Project Name: Sacred Heart Parking Lot Expansion

Project Address: 80 Sherman Str.

TO: Ellen Sanborn, Finance Department
FROM: Alexander Jaegerman, Planning Division Director
DATE: October 30, 2012
SUBJECT: Request for Release of Defect Guarantee
Sacred Heart Parking Lot Expansion, 80 Sherman Street
(ID# 2011-279 Lead CBL #048 F 005001)

Project Name:	EXPANSION OF PARKING LOT	Project ID:	2011-279
Project Address:	80 SHERMAN STREET	CBL:	048-F-005
Applicant:	ROMAN CATHOLIC BISHOP OF PORTLAND		
Planner:	SHUKRIA WIAR

C1.1

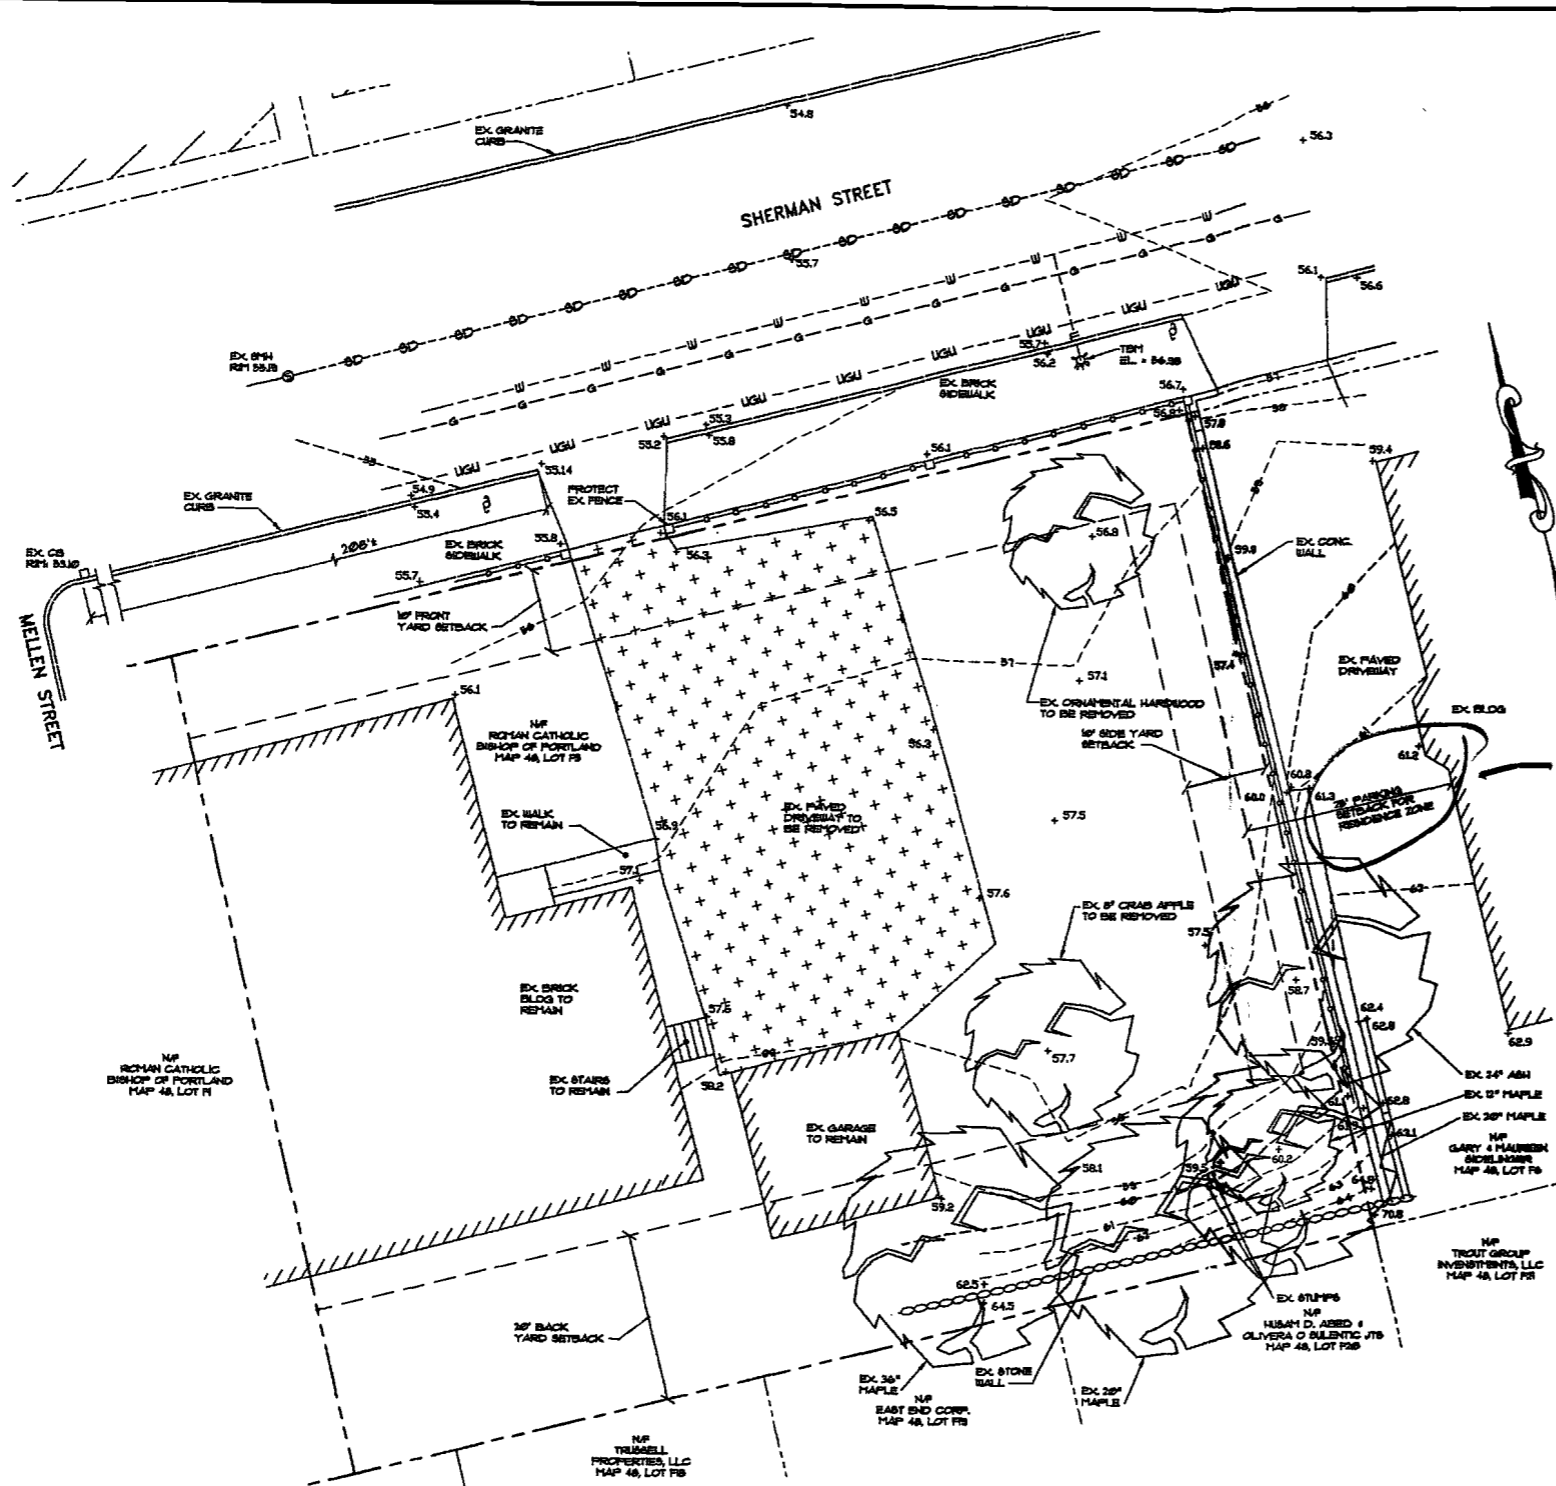
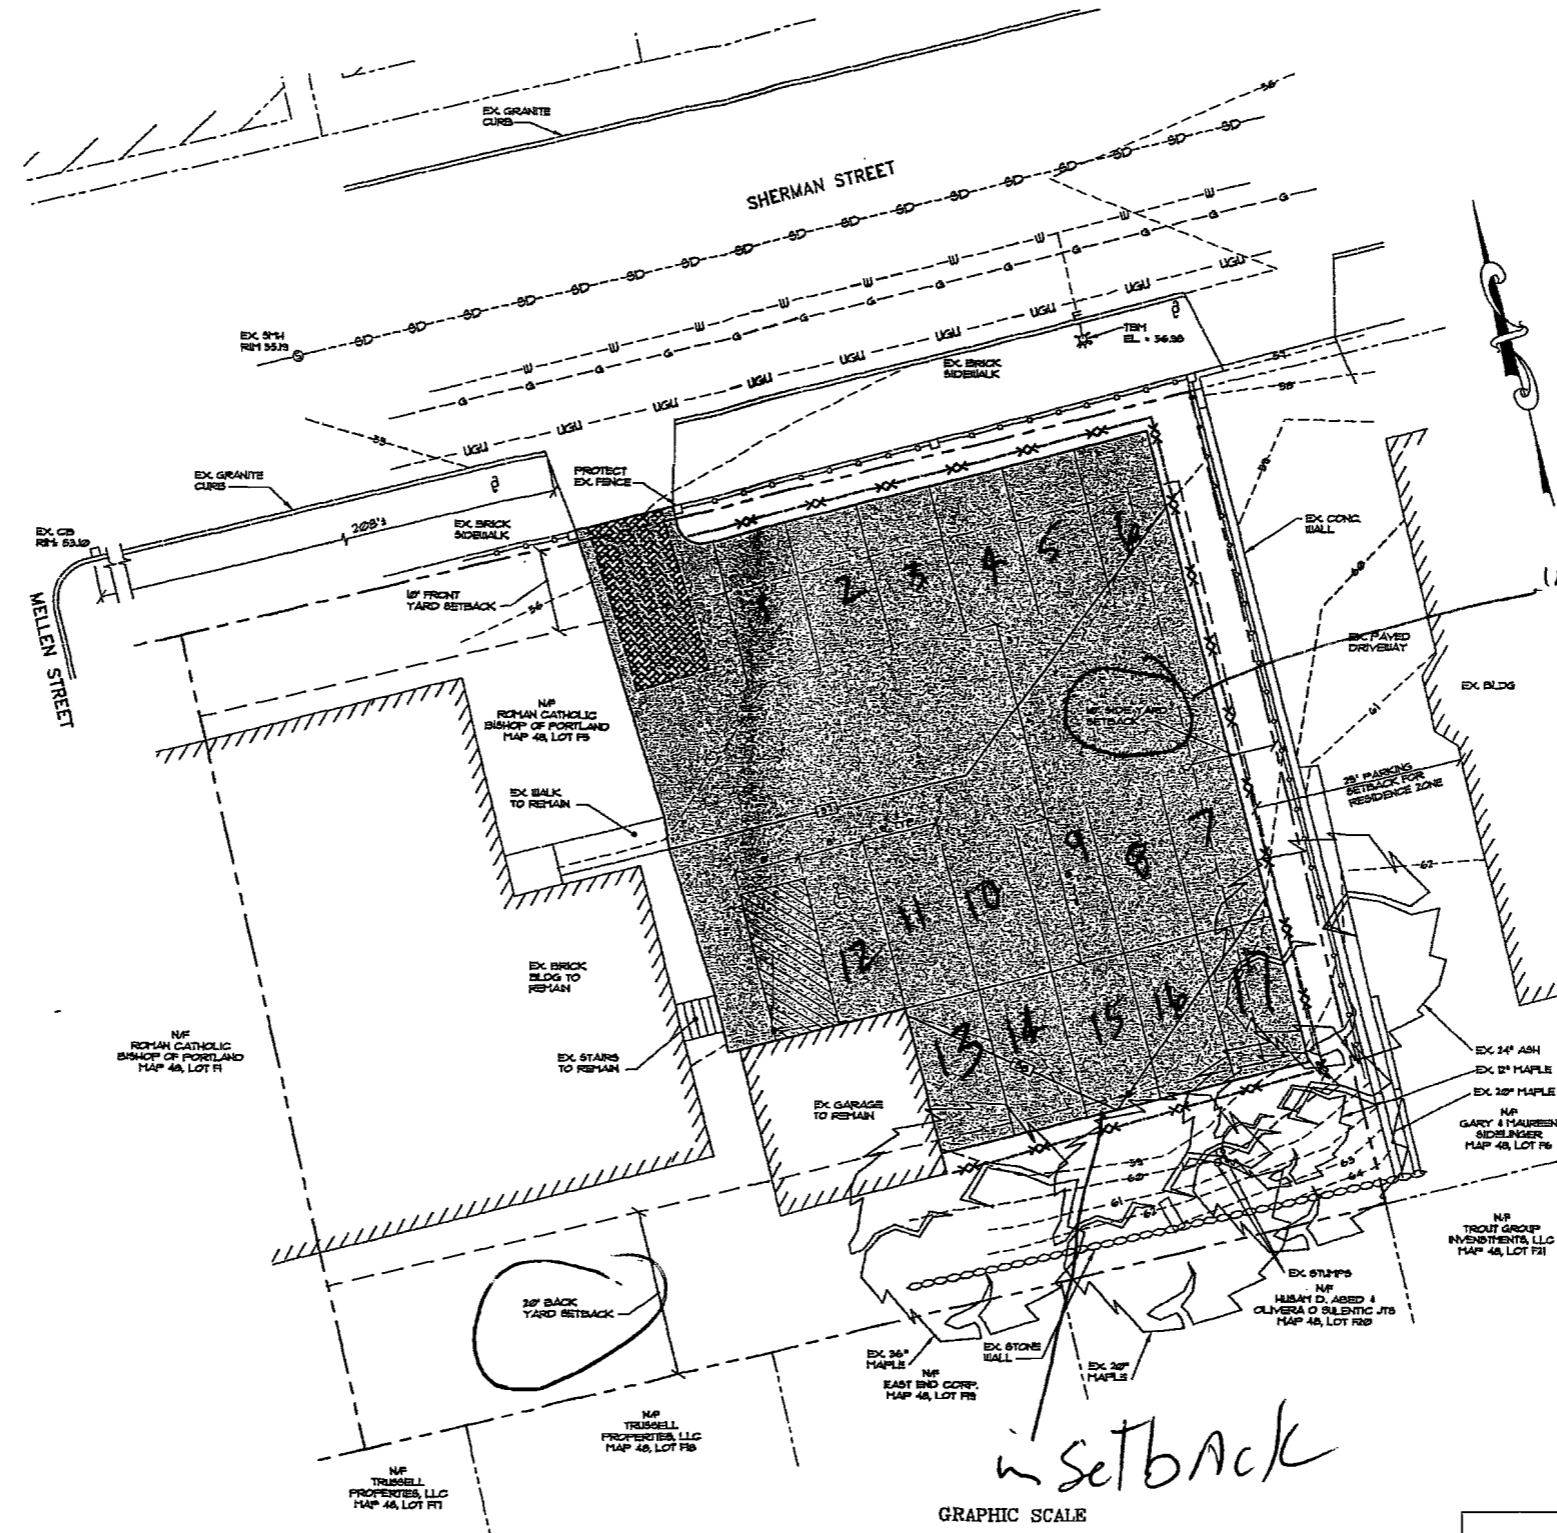
- a. That the applicant shall ~~pay a fee of \$1,635.00~~ ^{\$1568.70} as an infrastructure contribution for Portland's ongoing municipal stormwater treatment improvements.
- b. That the applicant shall modify the contours on the site plan to grade the stormwater drainage towards the vegetated strip along Sherman Street. This vegetated strip shall be depressed three inches below grade level of the adjacent parking lot.
- c. That there shall be no salt application used during the winter months, only sand shall be used in order to protect and preserve the proposed landscaping.

(two-way), where any site with driveway access to a street shall have a minimum width of 20 feet for two-way ingress and egress, with a preferred width of 24 feet, to allow the existing driveway width of 12' to remain.

In keeping with Alex Jaegerman's approval letter dated 8/17/11, please review the revised plans in association with the proposed work at the Church. Modifications include elimination of two parking spaces in the vicinity of the ornamental dogwood tree, revised landscaping and relocation of the bike rack.

Pursuant to required HP board revisions, the expanded parking area will accommodate a total of fifteen (15) vehicles for staff, and the proposed project will result in 2,241 square feet of impervious area. Given the reduction in impervious area, we request that the stormwater fee be reduced from \$1,635.00 to \$1,494.00 to reflect the new impervious total.

Grading will be adjusted to direct stormwater runoff to the landscaped area to the greatest extent possible given the existing topography and surface features on site. The Diocese will not use salt during the winter months.
